WEST SUSSEX COUNTY COUNCIL CONSULTATION

TO:	Arun District Council FAO: Amber Willard
FROM:	WSCC - Highways Authority
DATE:	28 September 2021
LOCATION:	Mildmay, Hook Lane, Chichester, PO20 3TE
SUBJECT:	AL/89/21/PL Demolition of existing property and erection of new 4 bed dwelling house with ancillary parking.
DATE OF SITE VISIT:	n/a
RECOMMENDATION:	More Information
S106 CONTRIBUTION TOTAL:	n/a

PROPOSED GROUND FLOOR PLAN

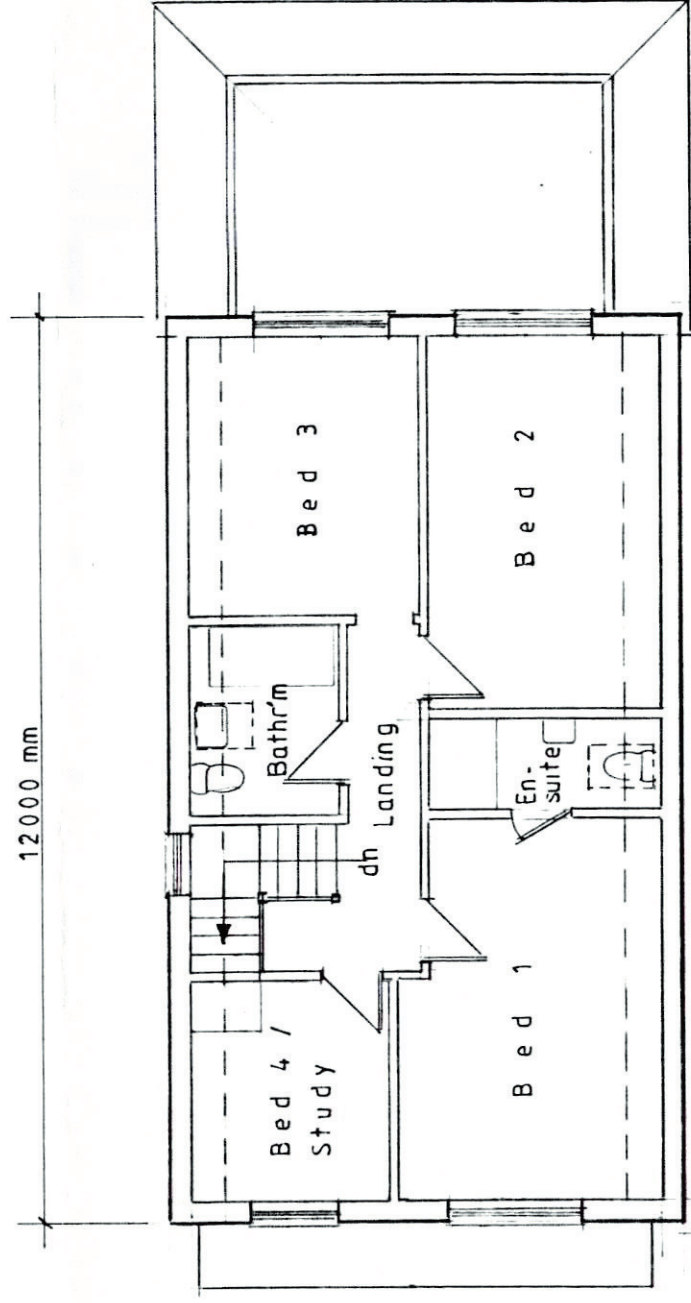
The application form details that no changes are proposed to the existing site access arrangement. However, parking has been demonstrated as being 3 spaces parked perpendicular across the site frontage. This parking arrangement does not seem achievable without alterations to the existing access point.

Please raised this with the applicant and clarify if any access works are proposed.

It seems pragmatic to provide a central point of access measuring no greater than 6.4 metres in width. This should provide access to the parking spaces as demonstrated. These access works would need to be implemented under licence to a specification obtained from WSCC Highways.

Any on-site parking should be provided in line with the Arun DC supplementary planning guidance for parking within residential developments. The site is located within Barnham which is within Parking Behaviour Zone 2. For a 4-bed dwelling in this location it would be anticipated that 3 car parking spaces would be required.
